# **Inadequate Treatment of Climate Change and Air Quality in the Environmental Statement**

The focus of this written representation is on Environmental Statement Chapter 13: Air Quality, Chapter 16: Greenhouse Gases and Chapter 18: Health and Wellbeing TR020005.

Diagram 3.3.1: Model performance before and after adjustment, Generic zone

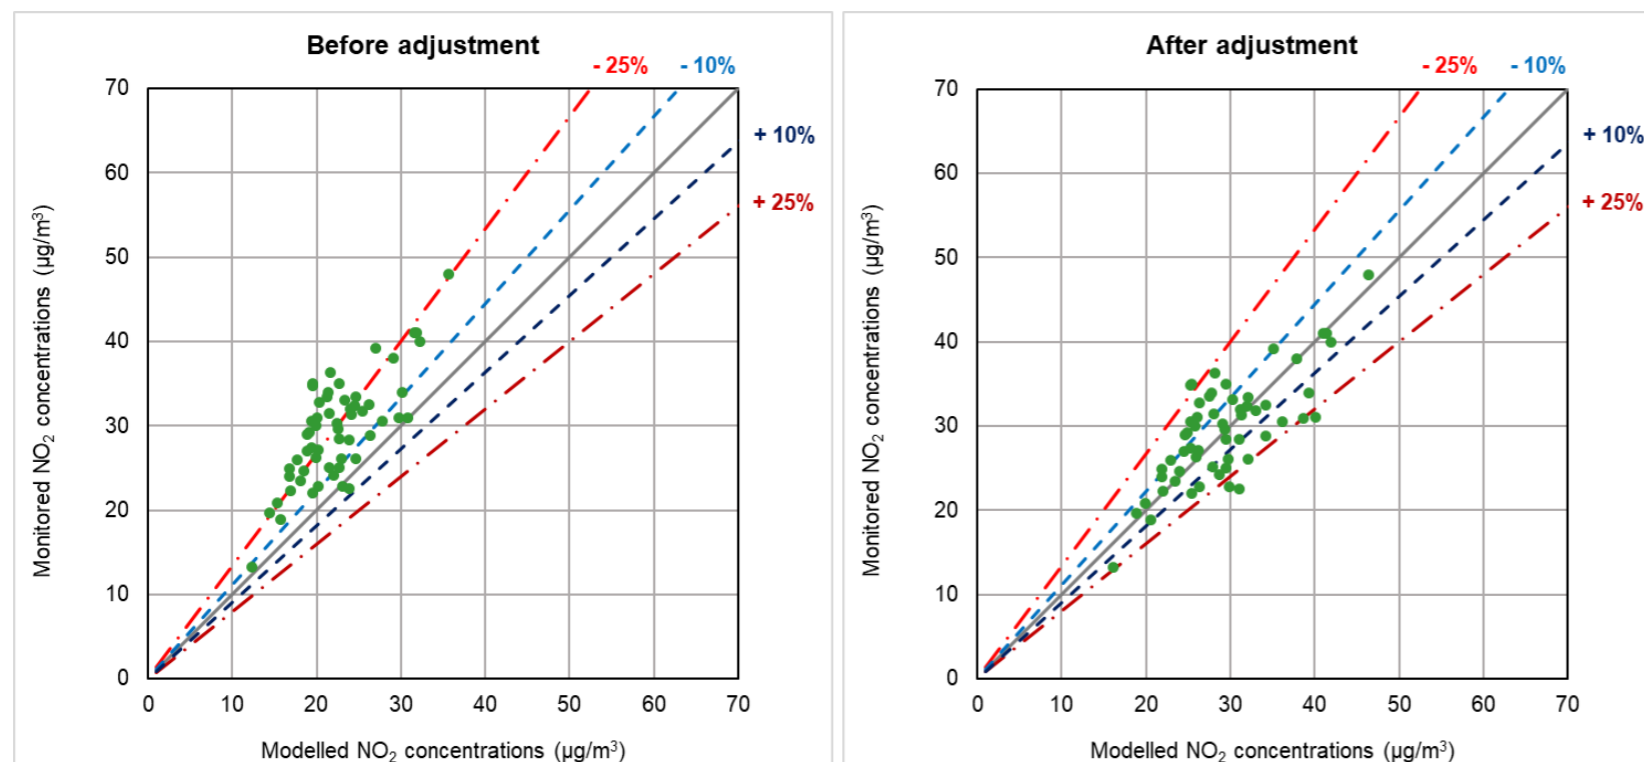
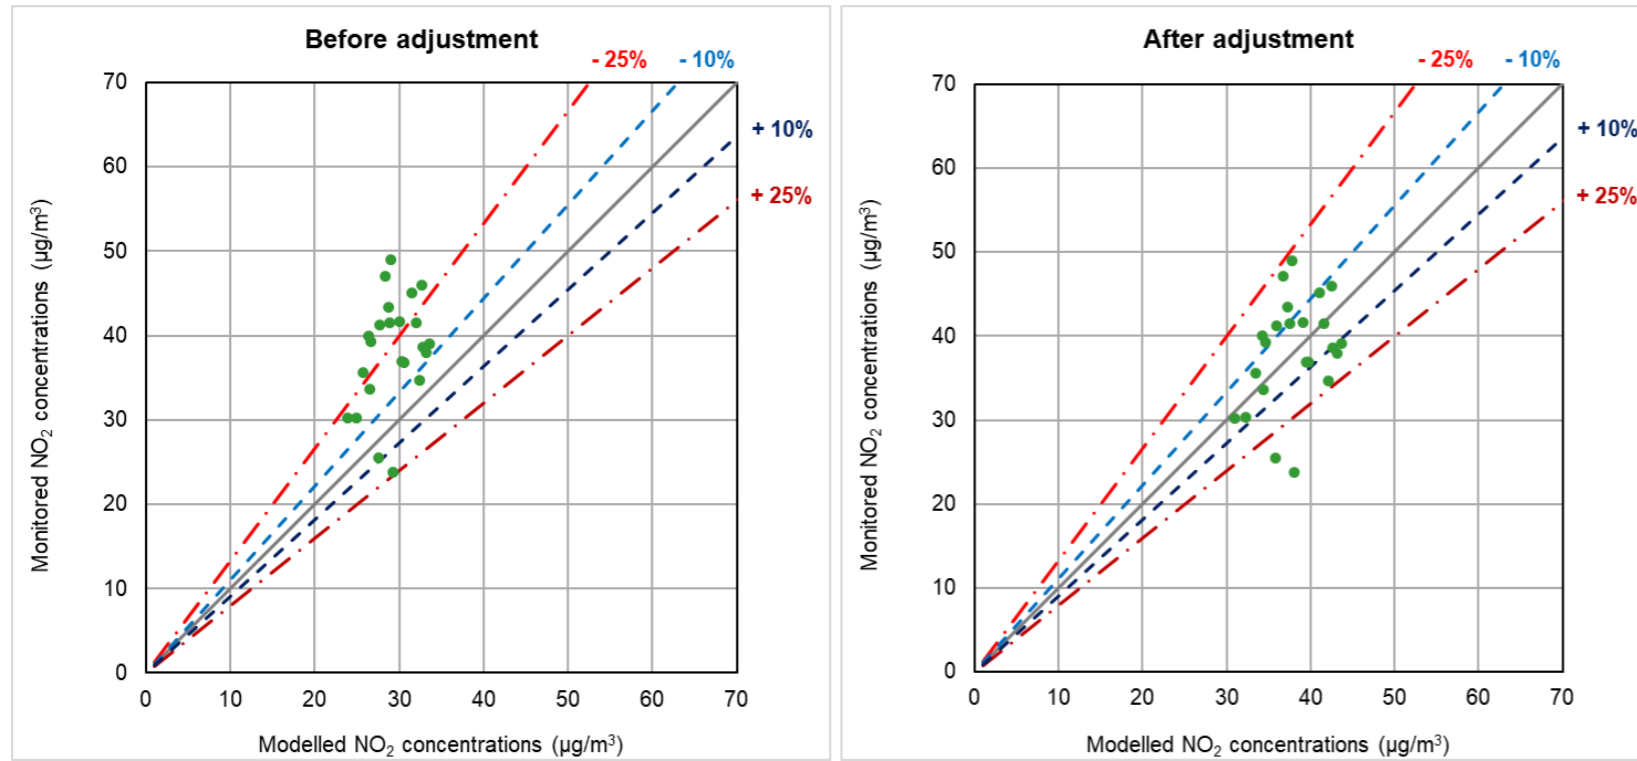
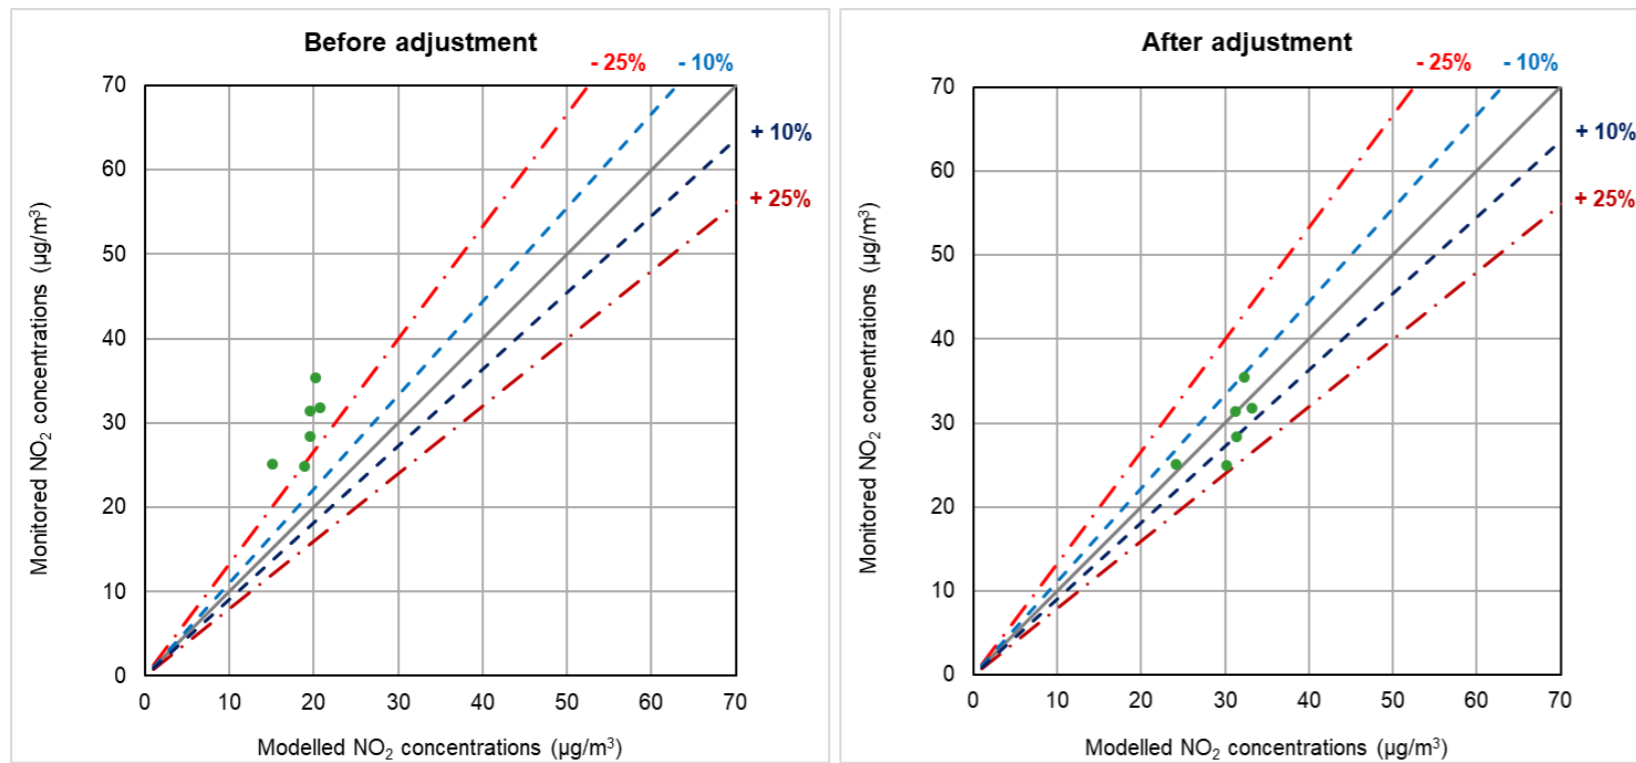
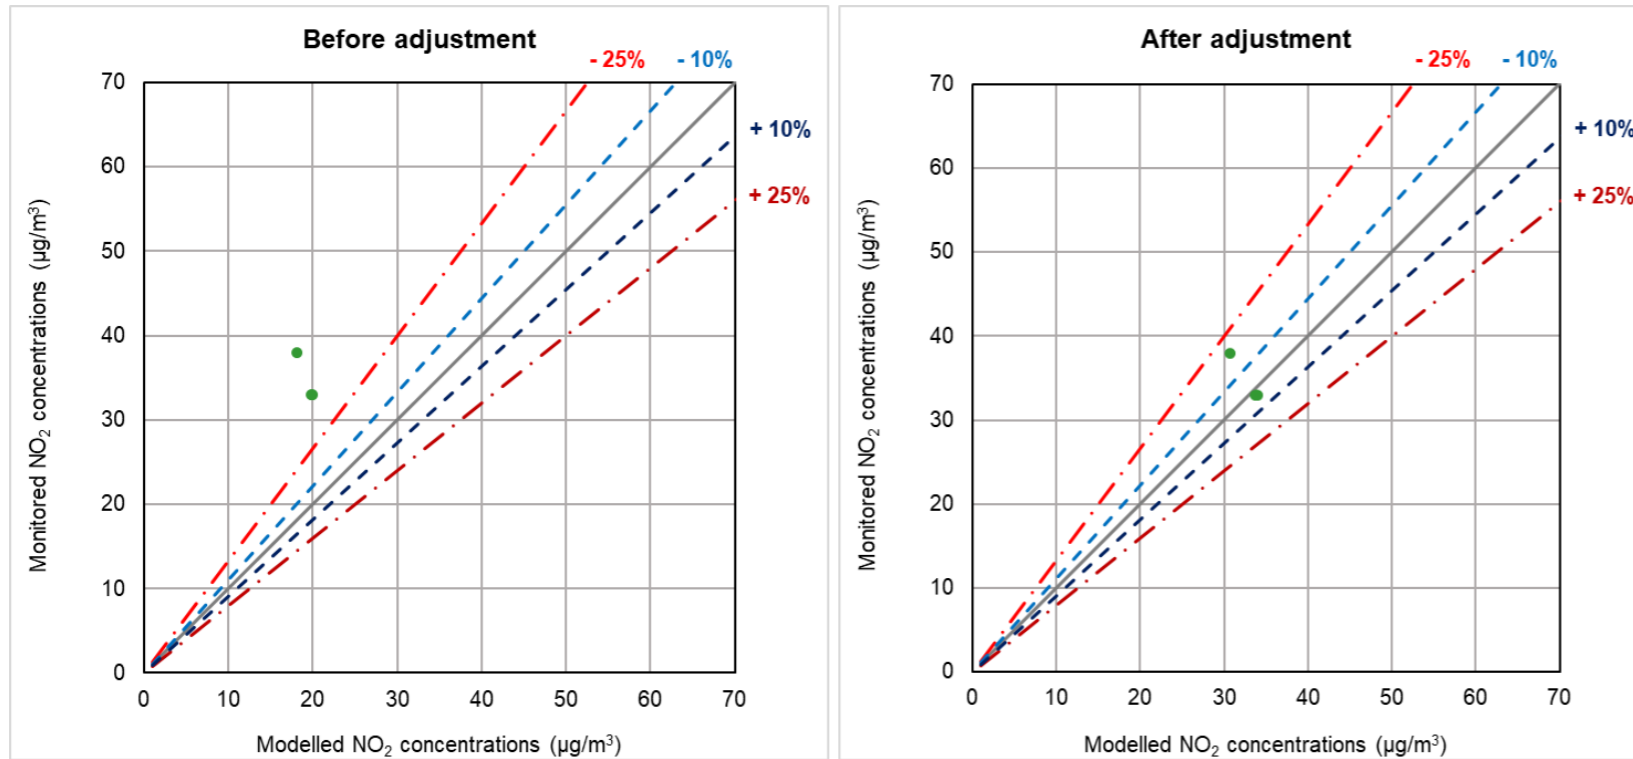
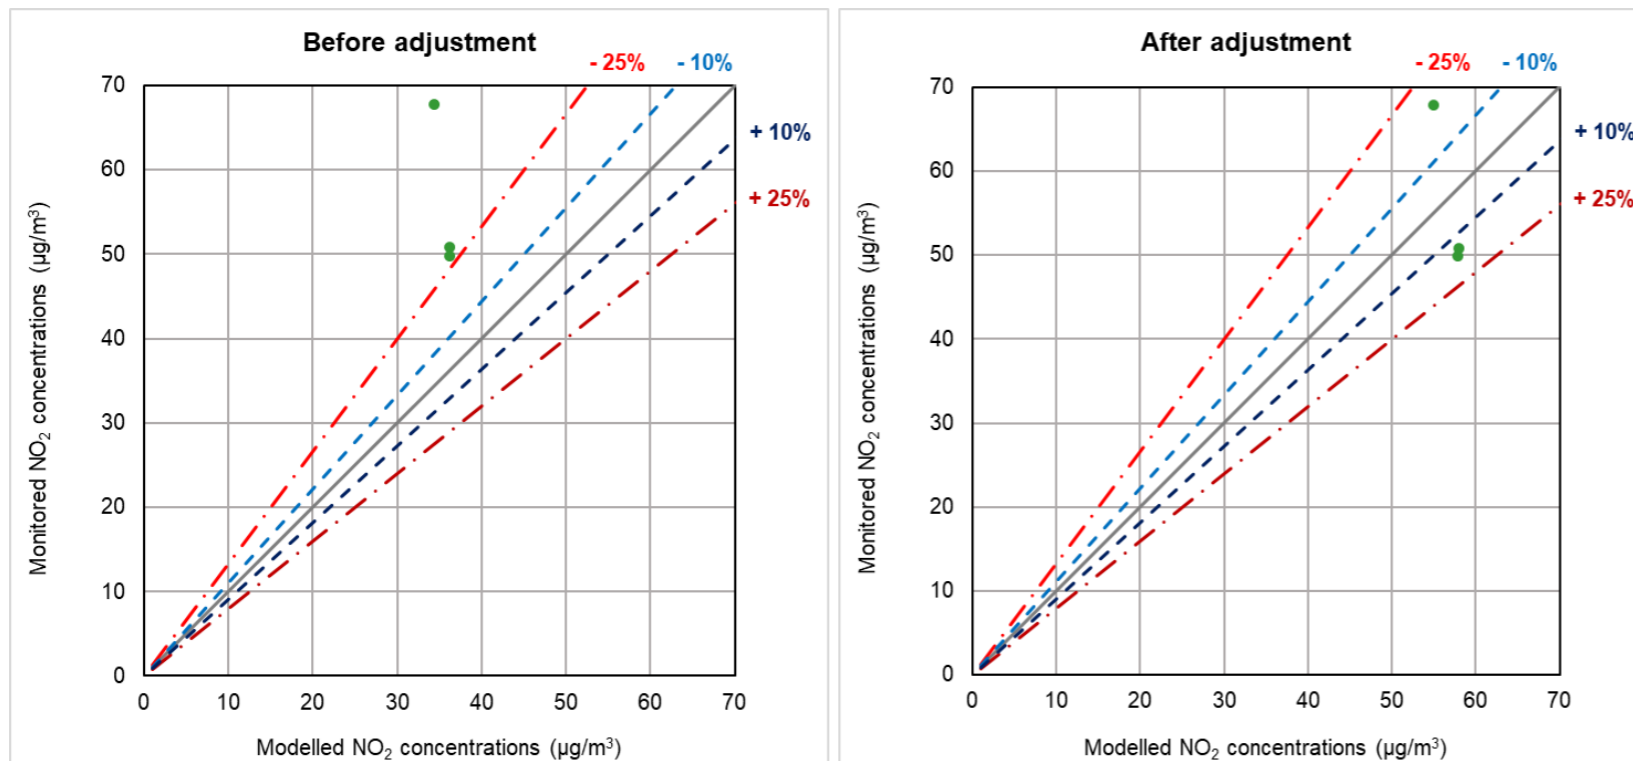
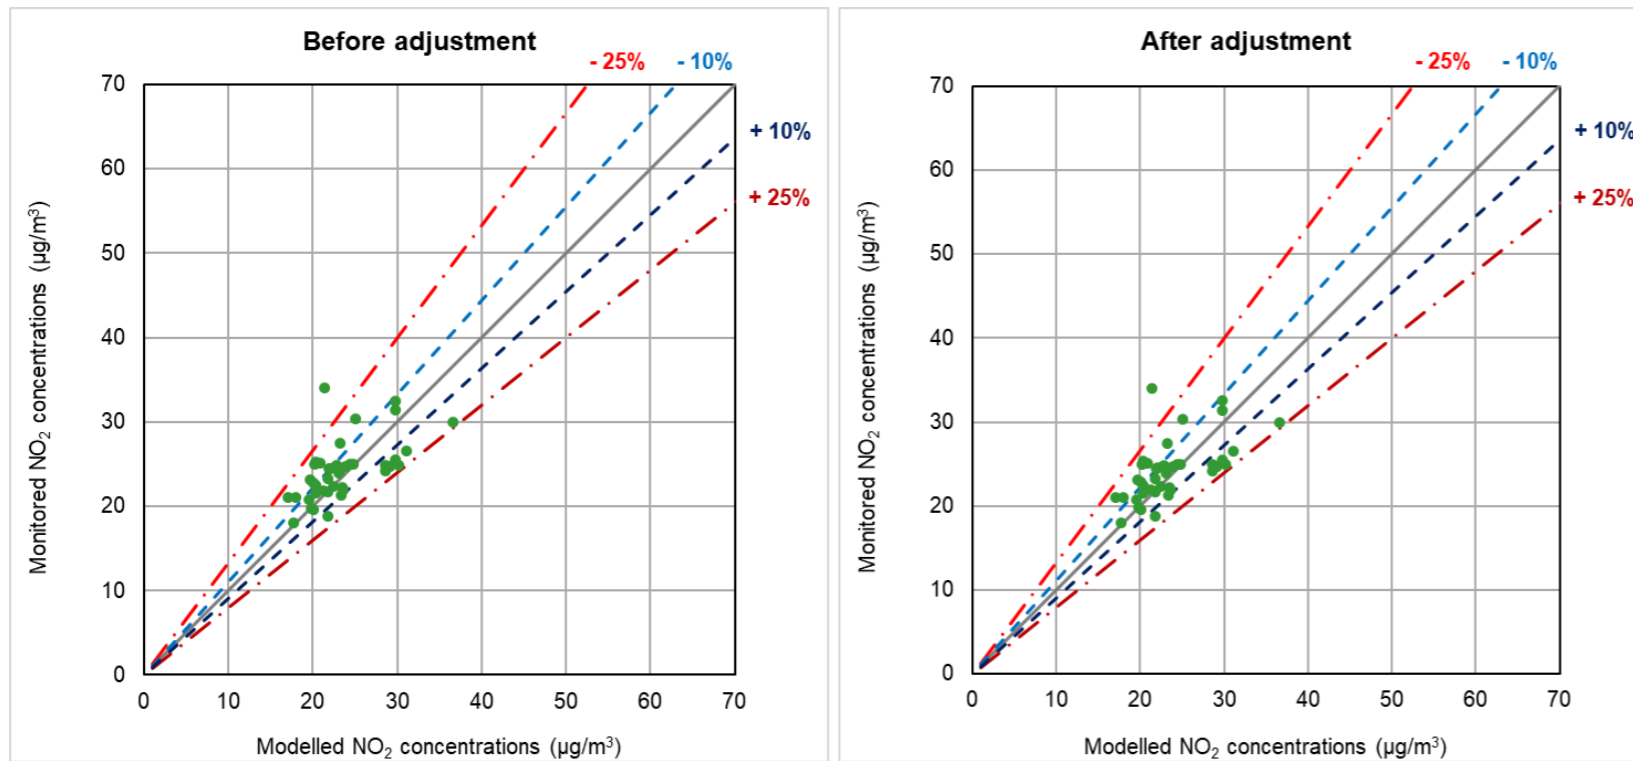
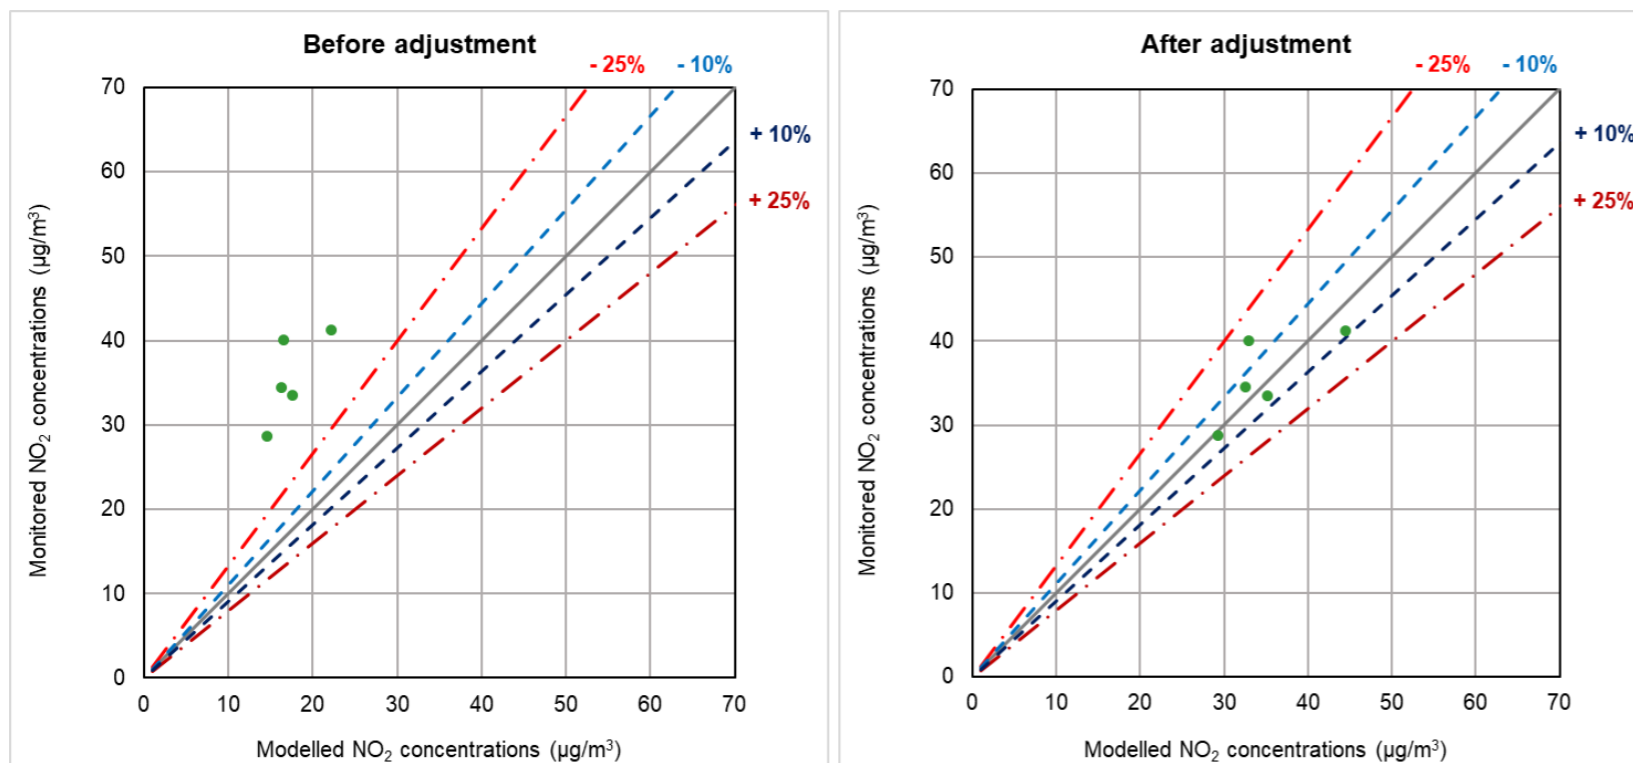
(31) The treatment of the correction to the modelled NO<sub>2</sub> calculations Appendix 13.6.1 of the Environmental Statement seems rather unscientific. If there is a systematic under prediction then some reason should be cited, possibly incorrect traffic emissions. There is discussion in the scientific community of whether emissions based on traffic cycles or real world emissions are best. Appendix 13.6.1 states that the adjustment for poor model performance is a multiplicative factor of 1.2 to 2 and a generic factor 1.3 is adopted. As NO<sub>2</sub>, or NO<sub>x</sub> derived PM<sub>2.5</sub> are the main contributions to the health risk impact (attributable lives lost *per year*) in the health risk assessment, it is important to get the NO<sub>x</sub> modelling right without incorporating correction factors. No results for NO<sub>x</sub> concentrations are presented in

(32) One wonders whether it is valid to apply a poor model, with such poor performance, to future years, if one does not know the reasons for its deficiencies. The Environmental Statement recognises that background air pollution concentrations may change considerably. In paragraph 4.4.3 in Appendix 13.4.1 assumptions regarding future ozone concentrations are made without justification, which could affect future NO2 concentrations.

(d) The modelling of NO2 concentrations is subject to rather **large** uncertainties. One should not use a model to predict future concentrations unless the deficiencies of the approach are understood. The uncertainty is acknowledged in Appendix 13.6.1 but the reasons are unknown.

3.3.1 As described in Section 3.1, there are a number of reasons why modelling and monitoring results differ. At the majority of sites, it can be observed in that there is tendency for the model to underestimate NO<sub>2</sub> concentrations and therefore an adjustment to the modelled concentrations was considered suitable.

One cannot just adjust a model prediction without explanation. Indeed if Gatwick Airport Limited thinks that the air pollution effects are insignificant, Gatwick Airport Limited should build in safety margins and apply these to obtain an upper bound on the expected effects.
